TO	CC
Sarah Jane Brazil	Kate Higgins Tom Sloane Chris Barling Ashley Cheong
COMPANY NAME	DATE
Office of Environment and Heritage	Original Issue- 21 December, 2016 Revised Issue- 19 January 2017
FROM	PAGES
Sydney Opera House	6 pages 3 attachments
SUBJECT	
Re: Sydney Opera House Function Centre Development and Ballet Rehearsal Reallocation (SSD7665)- Heritage Council Comments 30 November 2016 [REF DOC16/534144]

Further to the comments issued by the Heritage Council in **Sydney Opera House Function Centre Development and Ballet Rehearsal Reallocation (SSD7665)- Heritage Council Comments 30 November 2016 [REF DOC16/534144]** the Sydney Opera House wishes to make the following comments;

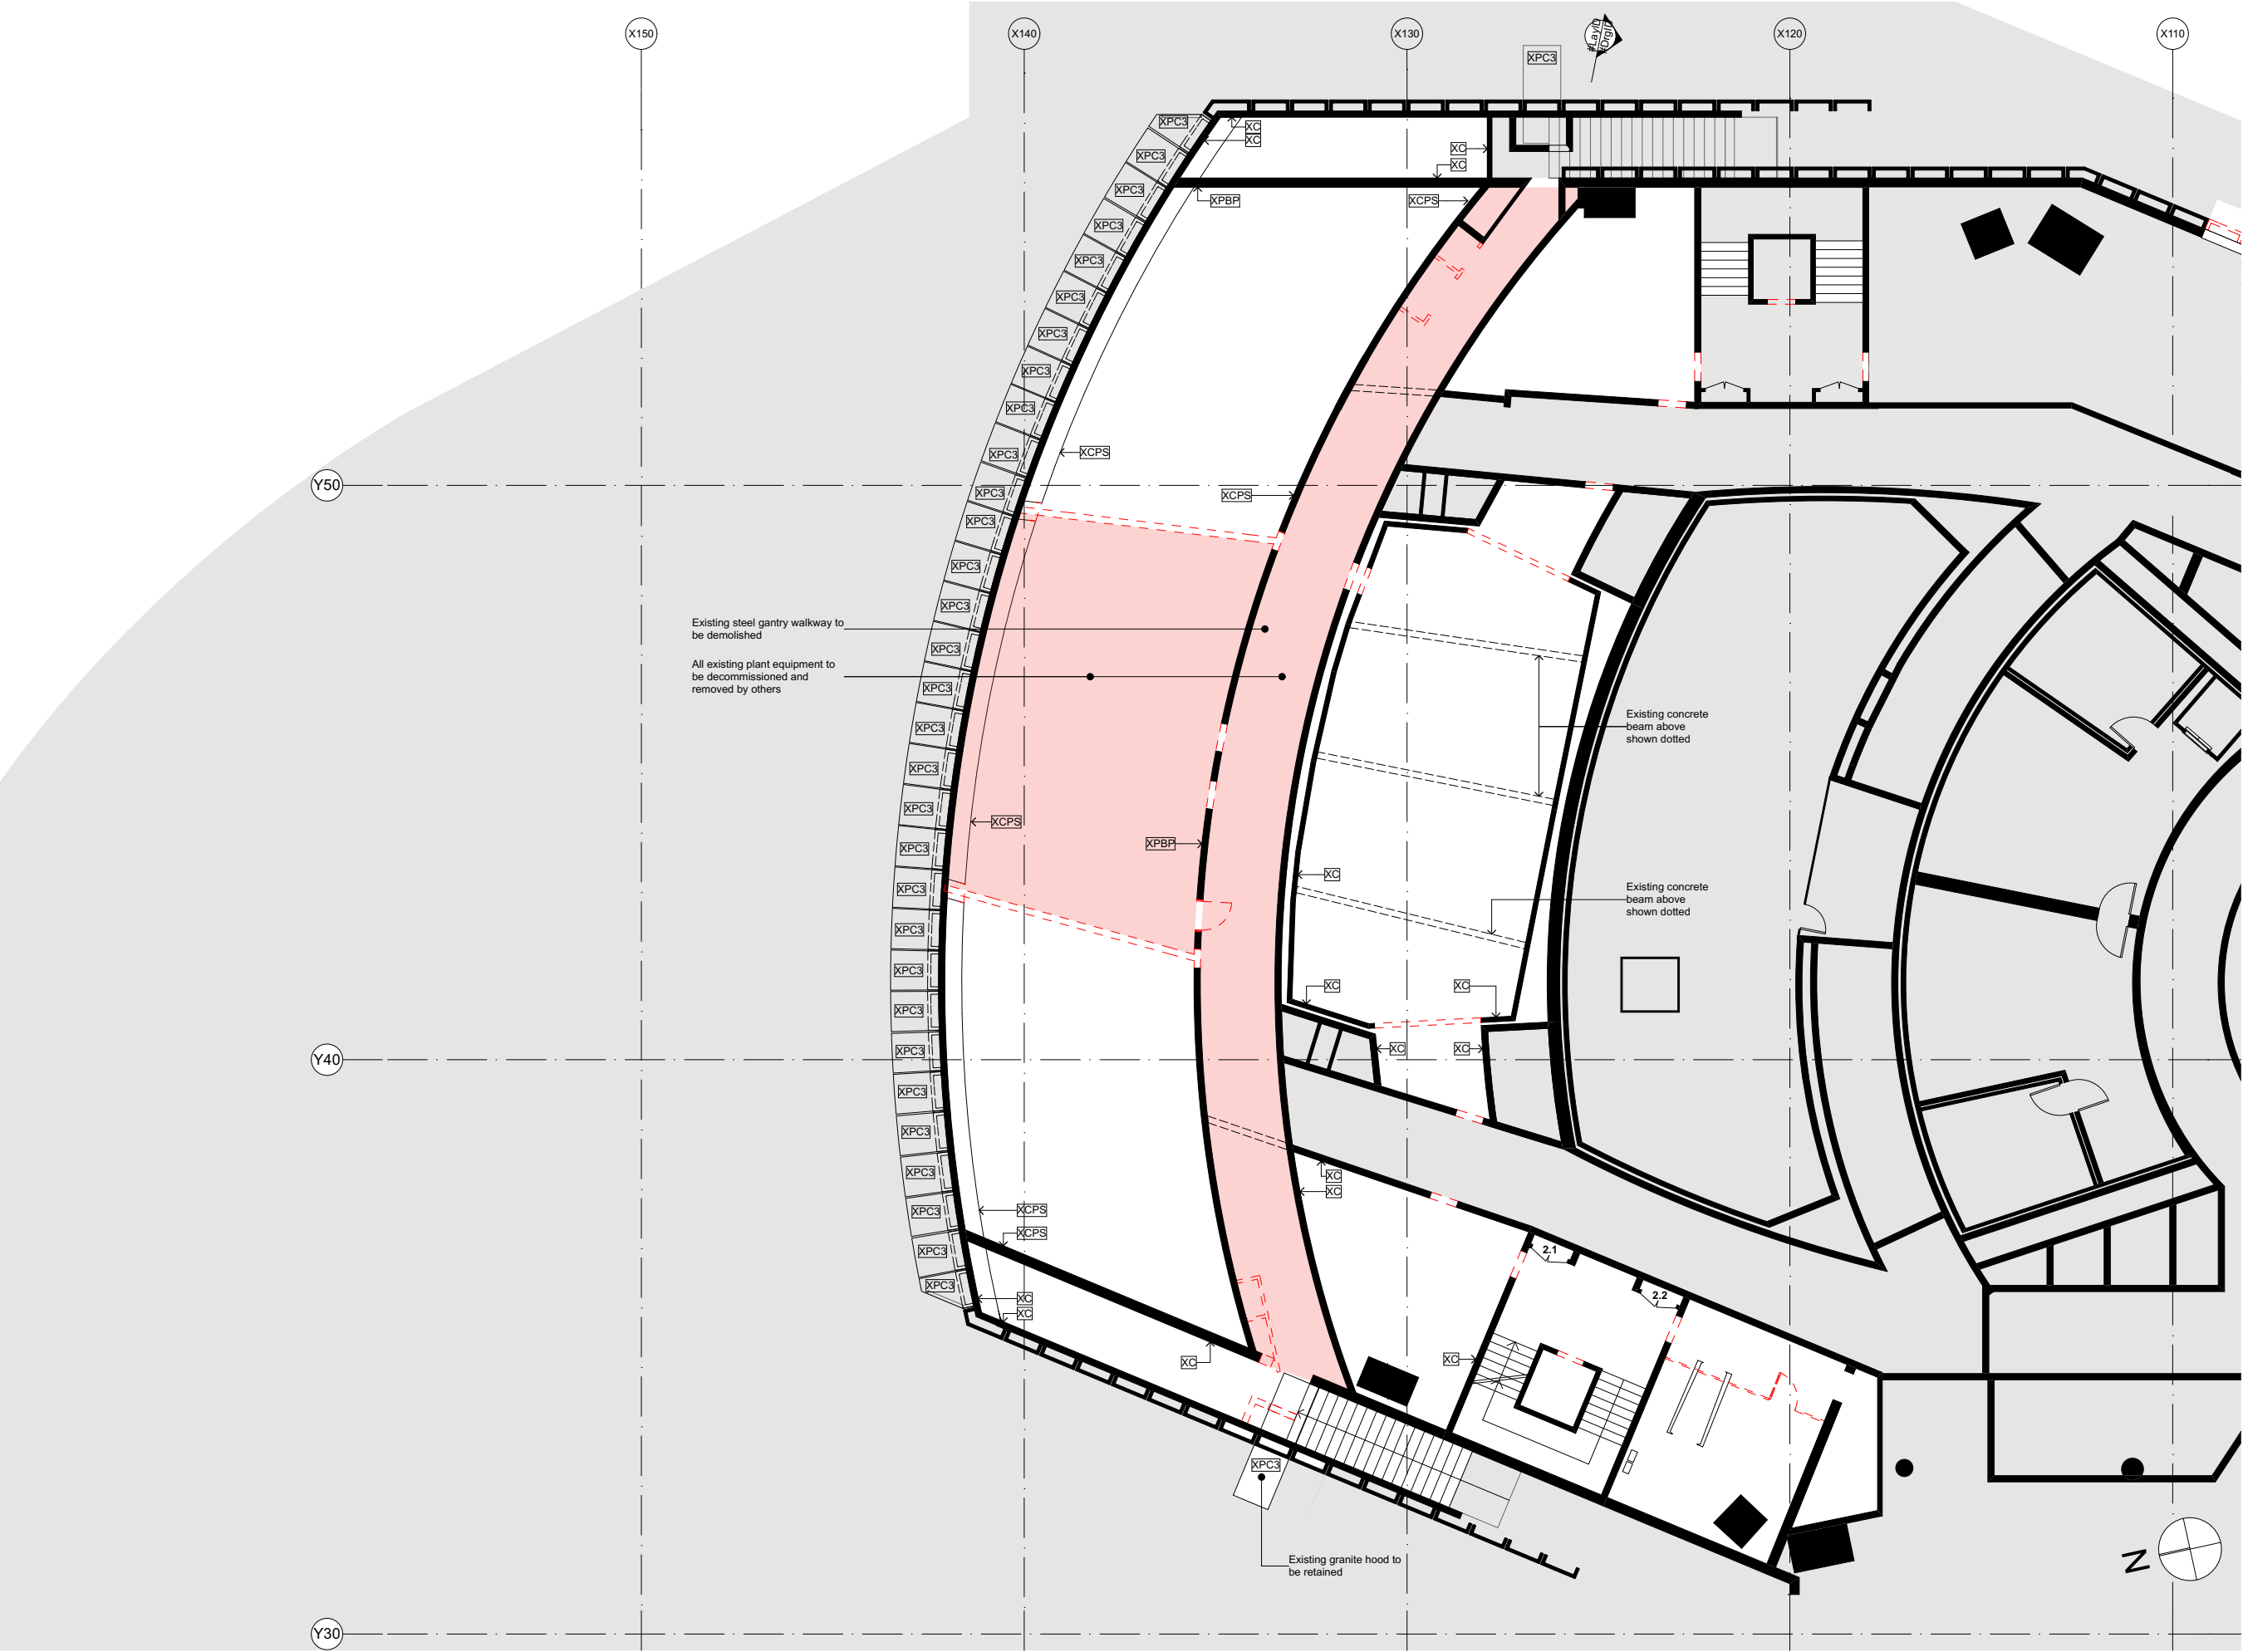
The submitted drawings show that the proposed alterations to the existing structure in order to form the three interconnected double height spaces for the function centre will require the demolition of the two existing concrete radial walls which are significant structural elements of the Podium. This will have an unacceptable impact on the significant fabric of the Opera House. It is considered that the walls must be retained and openings made within them so that a sufficient component of the original walls remain. This will provide clear evidence and understanding the original wall and spatial arrangement of the space.

The proposed new openings will require a significant extent of the existing radial walls to be removed. It is recommended that the size of the opening be reduced in order to retain a greater understanding of the nature of the original wall. It is noted that the applicant's heritage consultant has refrained from endorsing the proposed new openings.

The structural opening proposed by the Sydney Opera House is 5775 (w) x 3650mm (h), which was clarified on the 20/1/17.

This differs to the information provided in the supplementary plan drawing no. 49 BRTZG04 (SK-04) Revision A dated 07.11.16 to OEH initially as refinement of the structural analysis has meant that more of the wall can be retained.

“Opening heights of 2700mm, 3000mm, 3300mm and 3600mm were modeled and analysed in consultation with the EAP and it was agreed that opening heights of 3000mm and 3300mm caused an awkward relationship with the datum line of the glazing to the northern façade, which is 2700mm AFFL, 2700mm was too low and 3600mm was ideal and most appropriate in proportion.”

The Opera House does not believe that the opening size of 4755mm x 3000mm high (as per proposed condition New Works [3]) is not justifiable, as made clear by the Architect that it would provide an awkward relationship with the datum line and loss of amenity that comes with an opening width of 4755mm. Therefore SOH feel that the current opening size is justified.
